# Rezoning Transportation Analysis

Petition Number: 2024-004

Date	Description
2-21-24	First Review (JP)

RZ-1.0

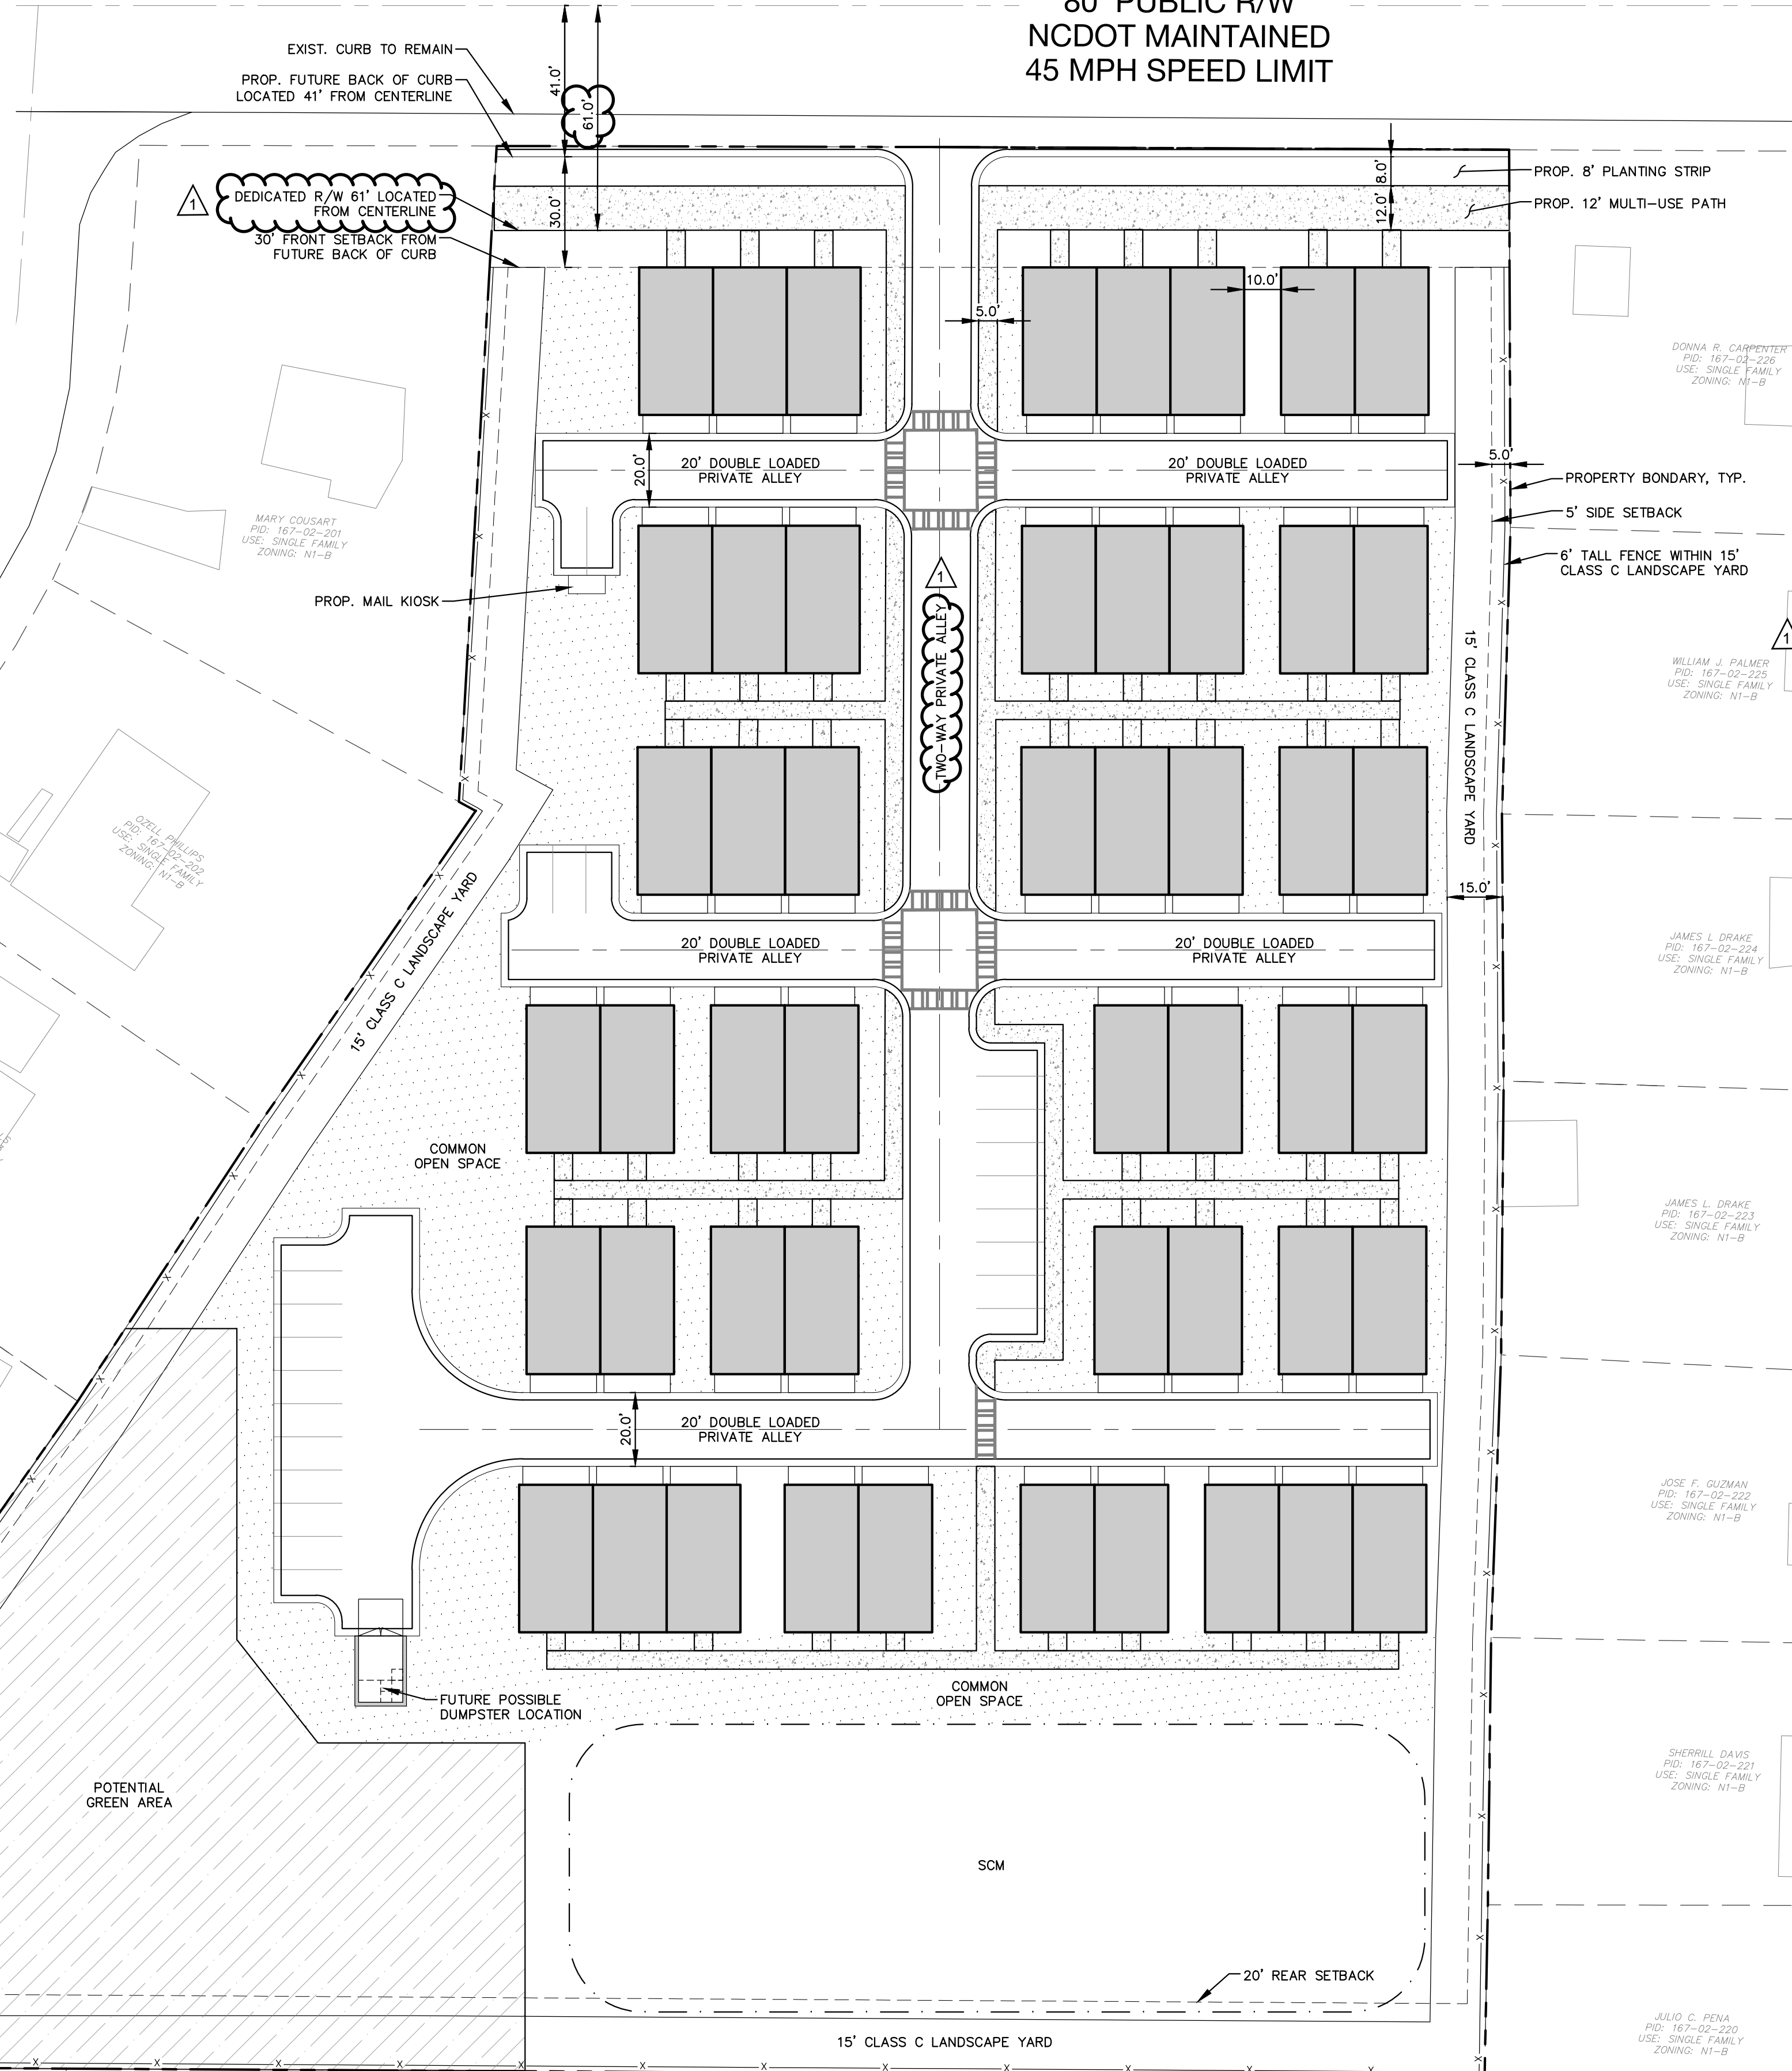
- a. **South Tryon Street:** Location of future curb and gutter is 41' from the centerline for a 6+ avenue with a shared use path.

Label and dimension the curb and gutter from the centerline for each road on the site plan.

- 3. Revise site plan and conditional note(s) to commit to dedicate 61-foot right-of-way from the road centerline. The site plan shall label and dimension the right-of-way from the road centerline.

- 4. In coordination with NCDOT, revise site plan and conditional notes to install a right turn lane into the site with 50' of storage.
- 5. Revise site plan to show the curb and gutter at the existing location. Due to the length of the sites frontage to South Tryon Street, the curb and gutter does not need to be relocated. Continue to show the future back of curb at its future location. Streetscape will be installed off of the future back of curb as shown.

- 6. Revise site plan to clarify the cross section of the main drive, and whether this is intended to be private or public.
- 7. Add a conditional note specifying "A Right-of-Way Encroachment Agreement is required for the installation of any non-standard item(s) (irrigation systems, decorative concrete pavement, brick pavers, etc.) within a proposed/existing City-maintained street right-of-way by a private individual, group, business, or homeowner's/business association. An encroachment agreement must be approved by CDOT prior to construction/installation. Contact CDOT for additional information concerning cost, submittal, and liability insurance coverage requirements."
